TR010037
14 December 2021

Application by Highways England for an Order Granting Development Consent for the A47/A11 Thickthorn Project

Change Request(s)

Figure 2.1 – Change to the alignment of the A11-A47 Connector Road

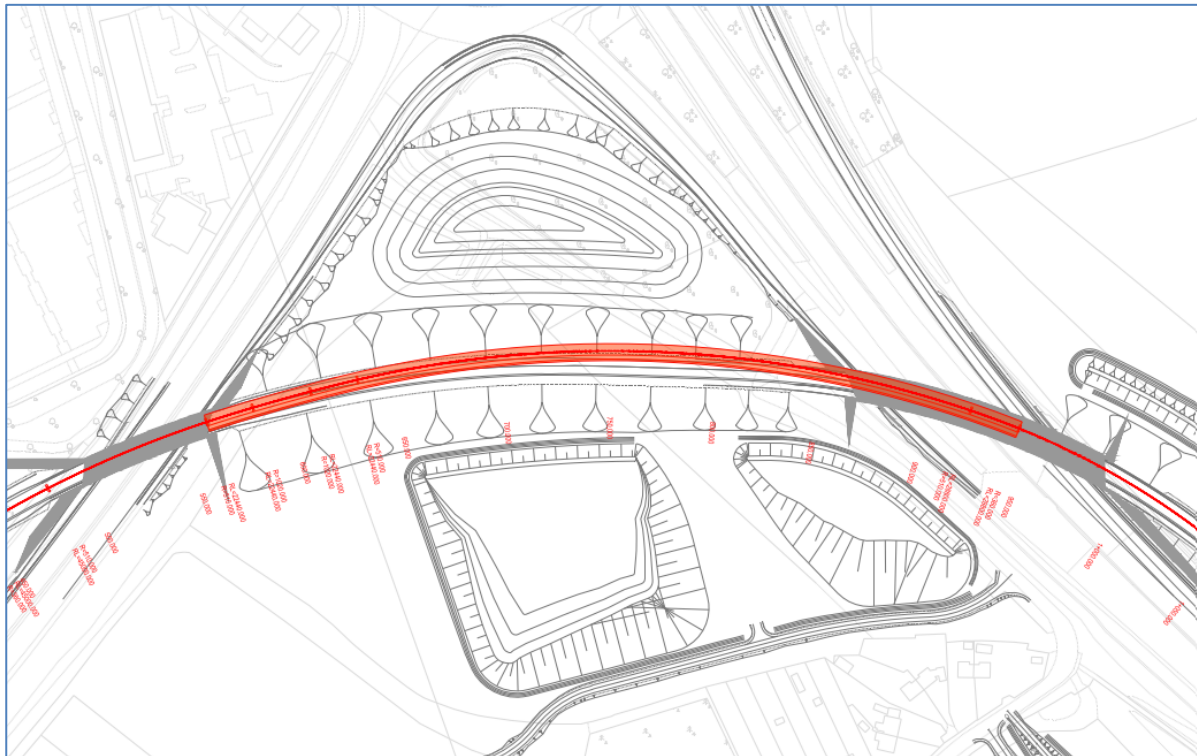
3. Change to the alignment of the A11/A47 Connector Road

The alignment of the A11/A47 Connector Road is proposed to be amended to reduce the cross section of the Cantley Lane Underpass. The ExA notes the change would reduce the requirements for construction materials and excavation of in situ material.

The horizontal curvature of the road is proposed to be amended so that at the apex of the curve the centreline of the road is approximately 7 metres to the north of the current centreline. The difference reduces to zero at the entrance to the Cantley Wood Underpass to the east, and at the exit from the Wards Wood underpass to the west as the proposed alignment ties back in with the current alignment. The apex of the curve referred to runs in the opposite direction to the nearby scheduled monument Two Tumuli in Big wood.
